WEST SUSSEX COUNTY COUNCIL CONSULTATION

TO:	Arun District Council FAO: A Wood
FROM:	WSCC - Highways Authority
DATE:	15 May 2020
LOCATION:	The Tudor Close Public House Ferringham Lane Worthing BN12 5NQ
SUBJECT:	FG/46/20/PL Conversion of the existing Public House (Class A4) to create 7 No residential units comprising 5 No 1-bedroom units & 2 No 2-bedroom units & the erection of 2 No 2-bedroom semi-detached chalet bungalows with associated car parking & landscaping. This application may affect a Public Right of Way.
RECOMMENDATION:	No Objection

Proposed Block Plan

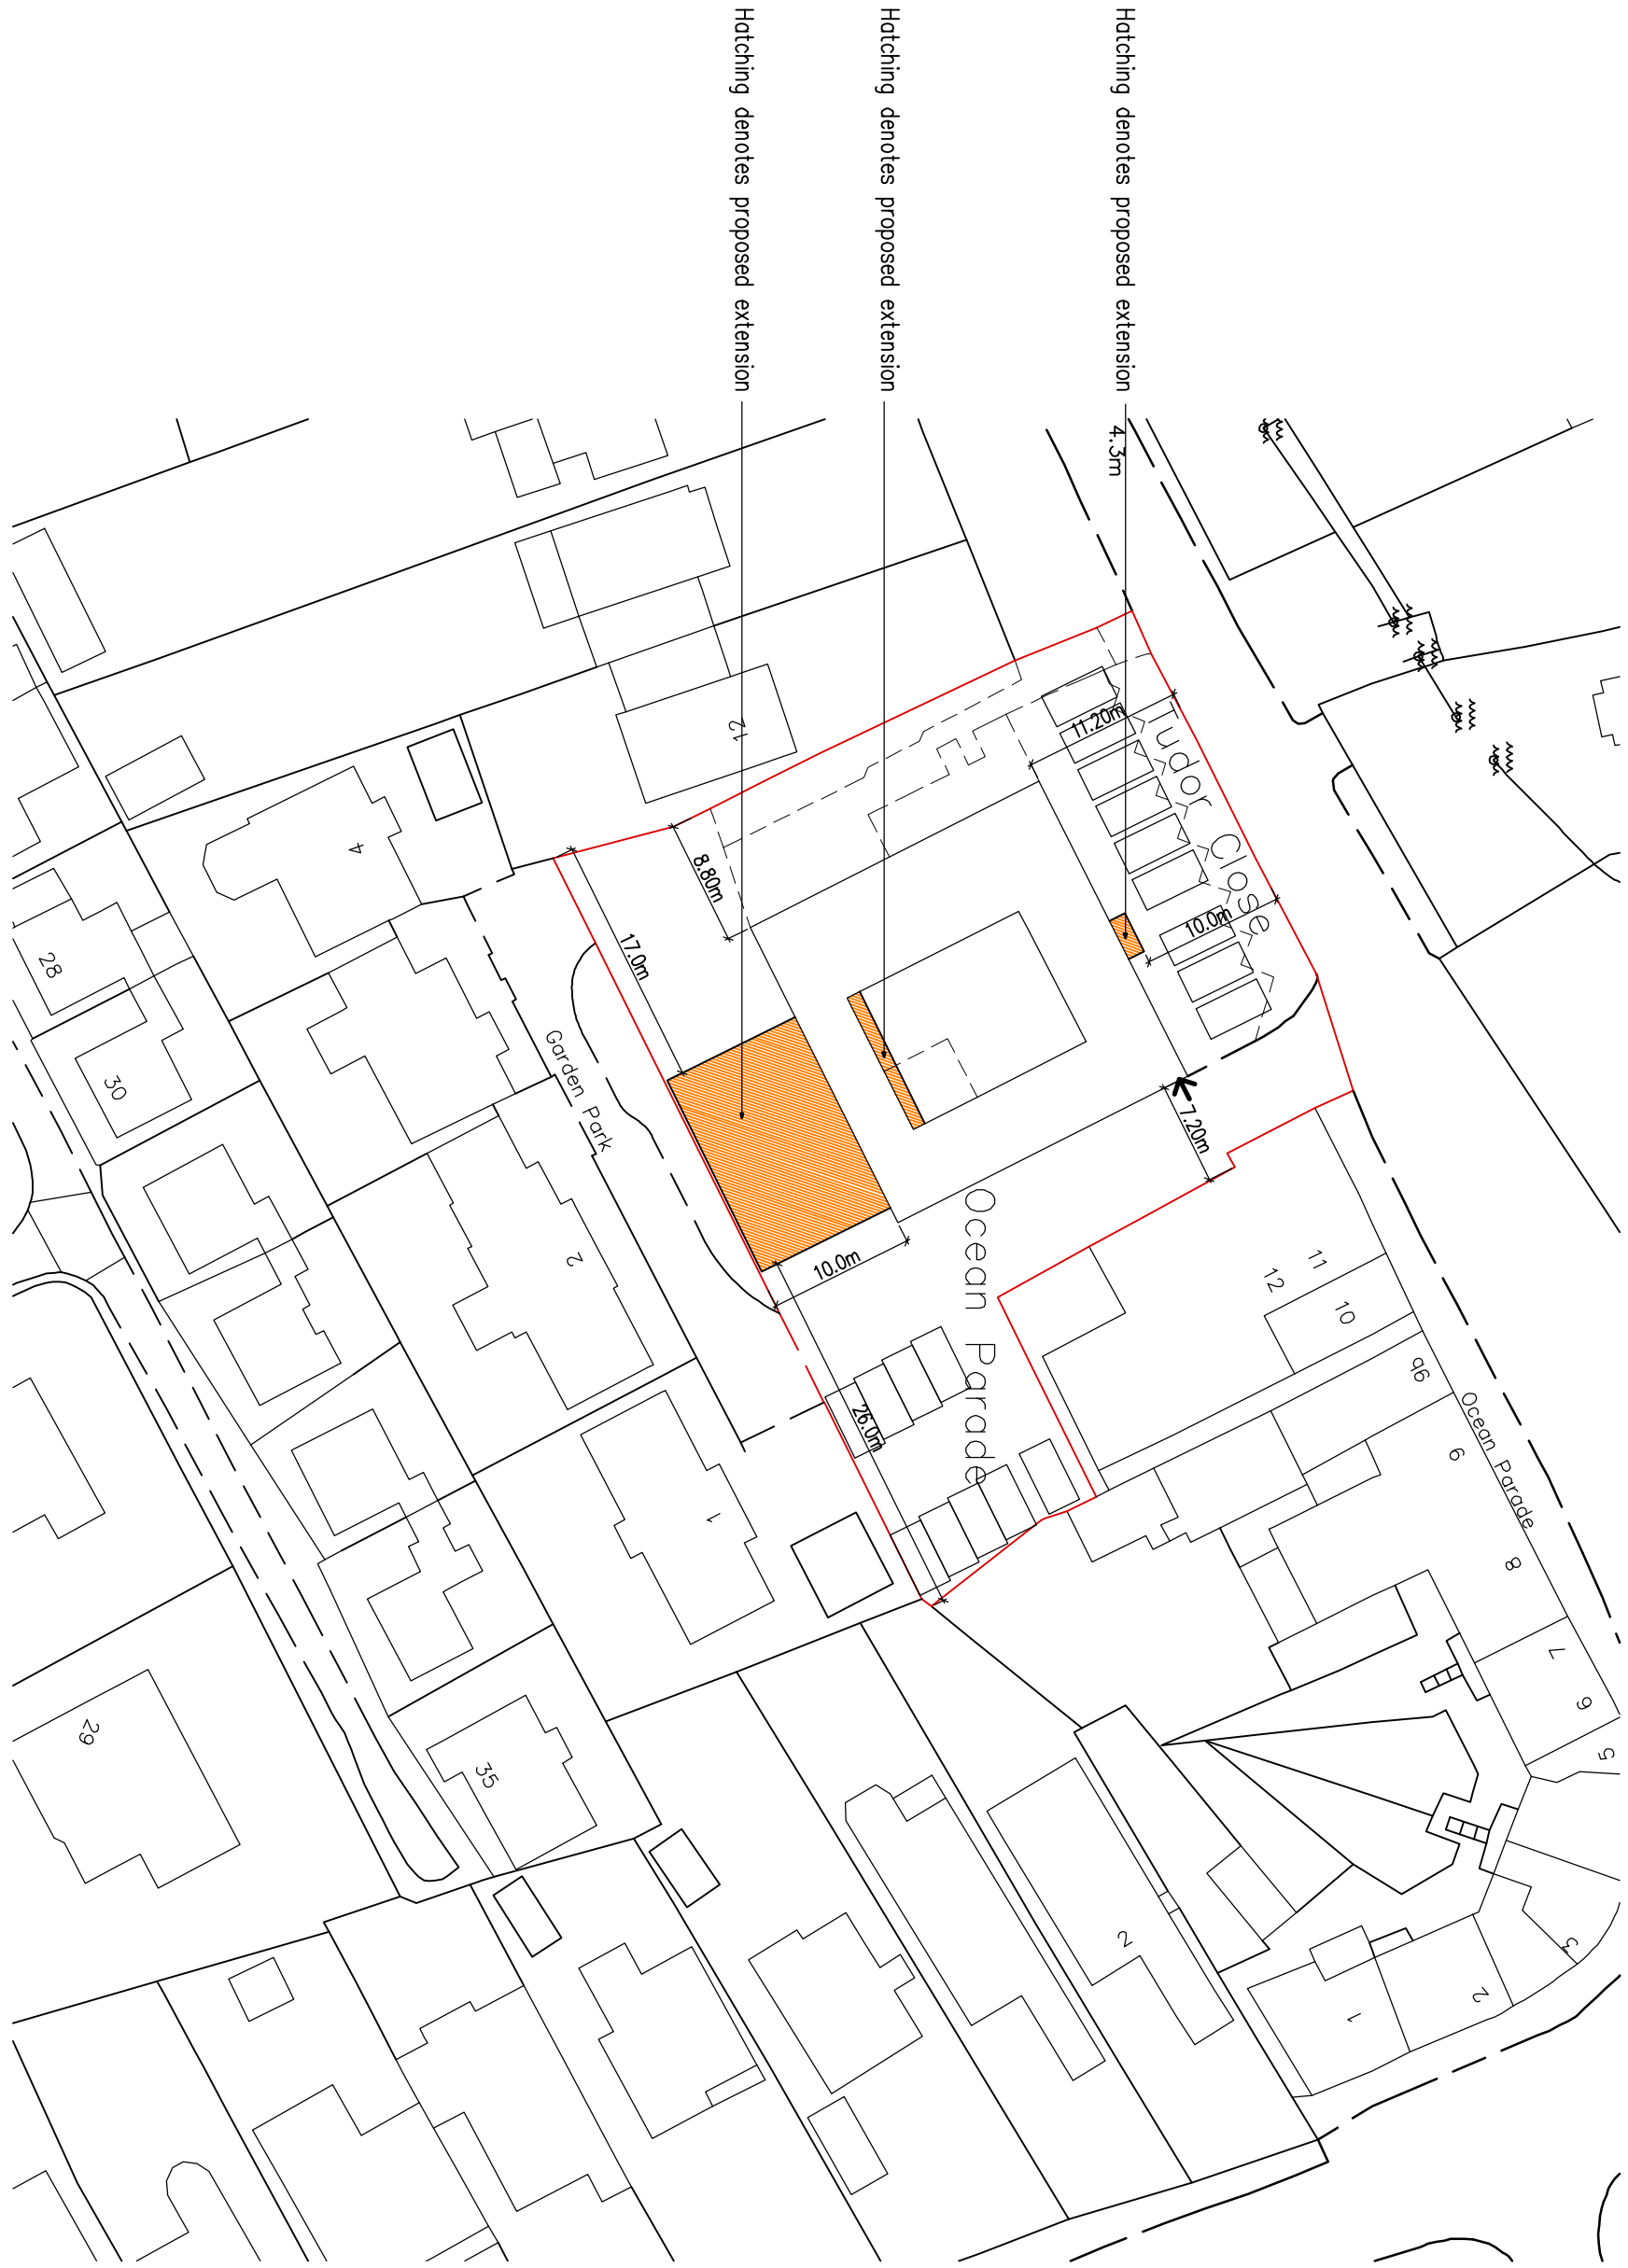
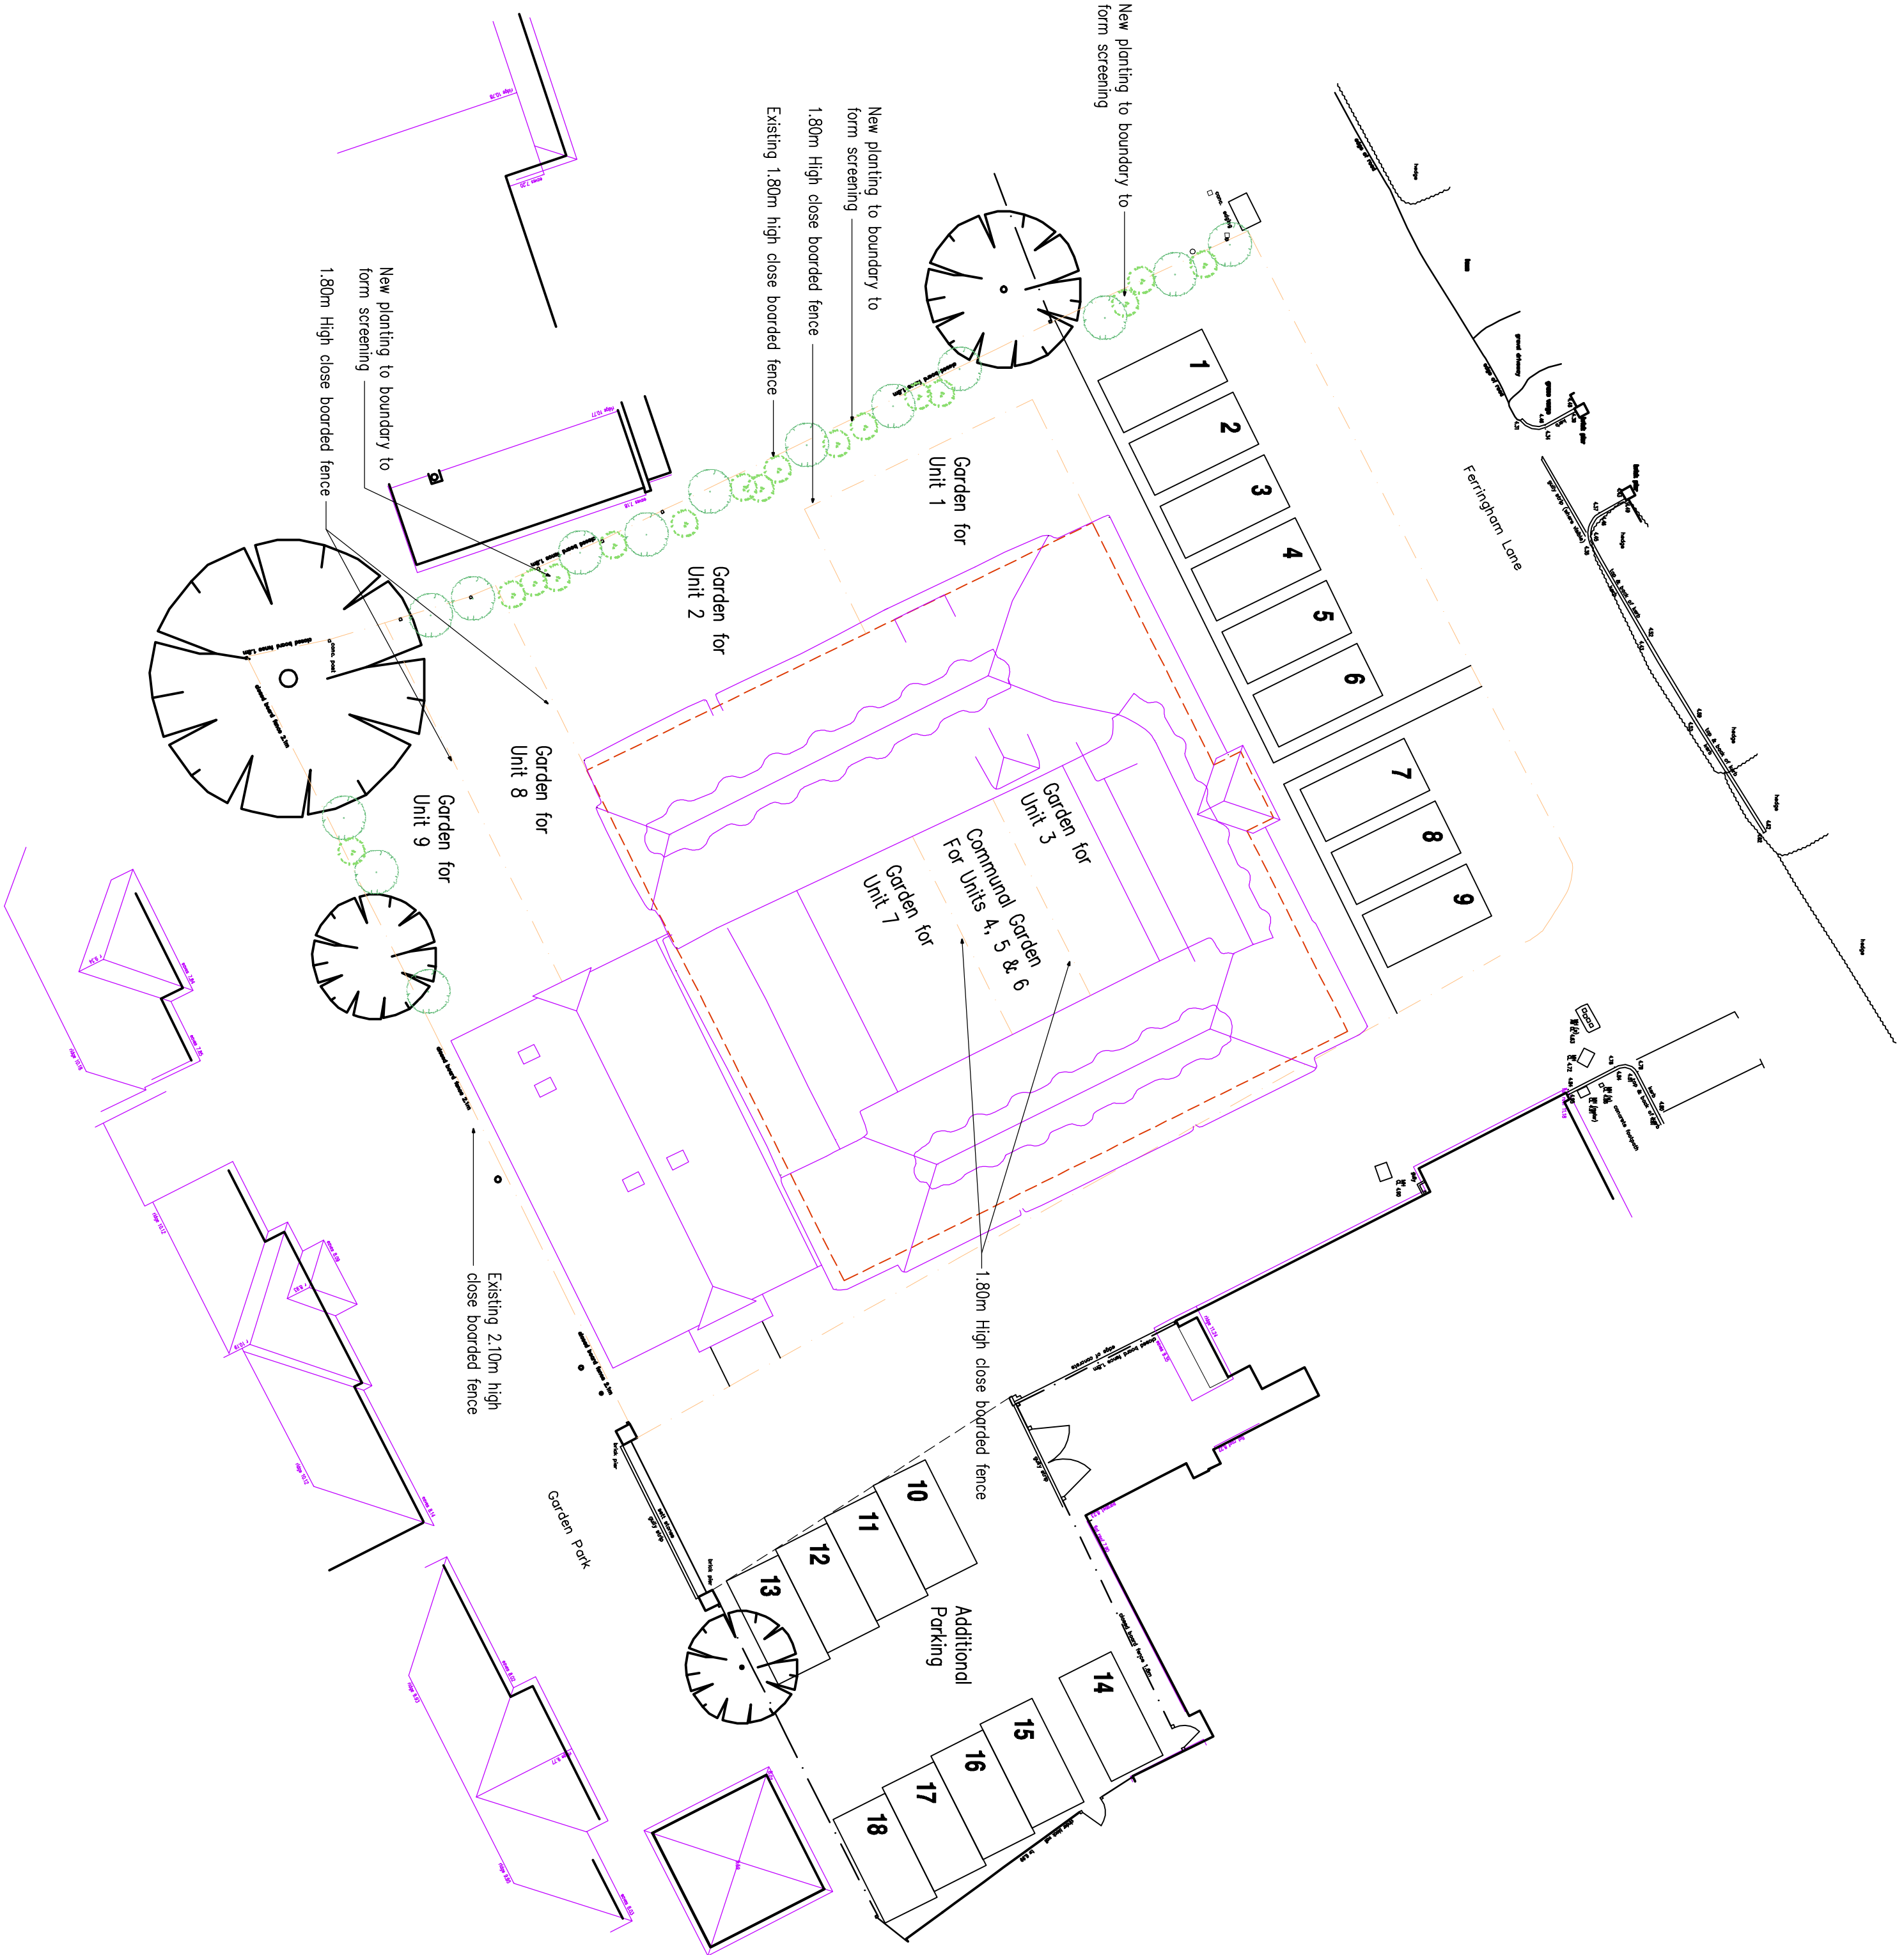
Under Arun Supplementary Planning Document (SPD) the development could see a parking demand for 18 x spaces (where Ferring is in Zone 2 and 2 x spaces should be provided per 1/2 bedroom unit. The Block Plan indicates 18 x spaces total with 9 x spaces fronting Ferringham Lane and 9 x spaces further within the site.

Manoeuvring space for the area marked 'additional parking' appears restrictive and may require multipoint manoeuvres. This is not anticipated to cause a highway safety concern though the Local Planning Authority (LPA) may wish to assess this layout from an amenity point of view.

Local mapping shows on-street parking on Ferringham Lane that may be taken away by required access to the 9 x spaces proposed adjacent. Any new access from the private lane should gain consent from proprietor of Ferringham Lane.
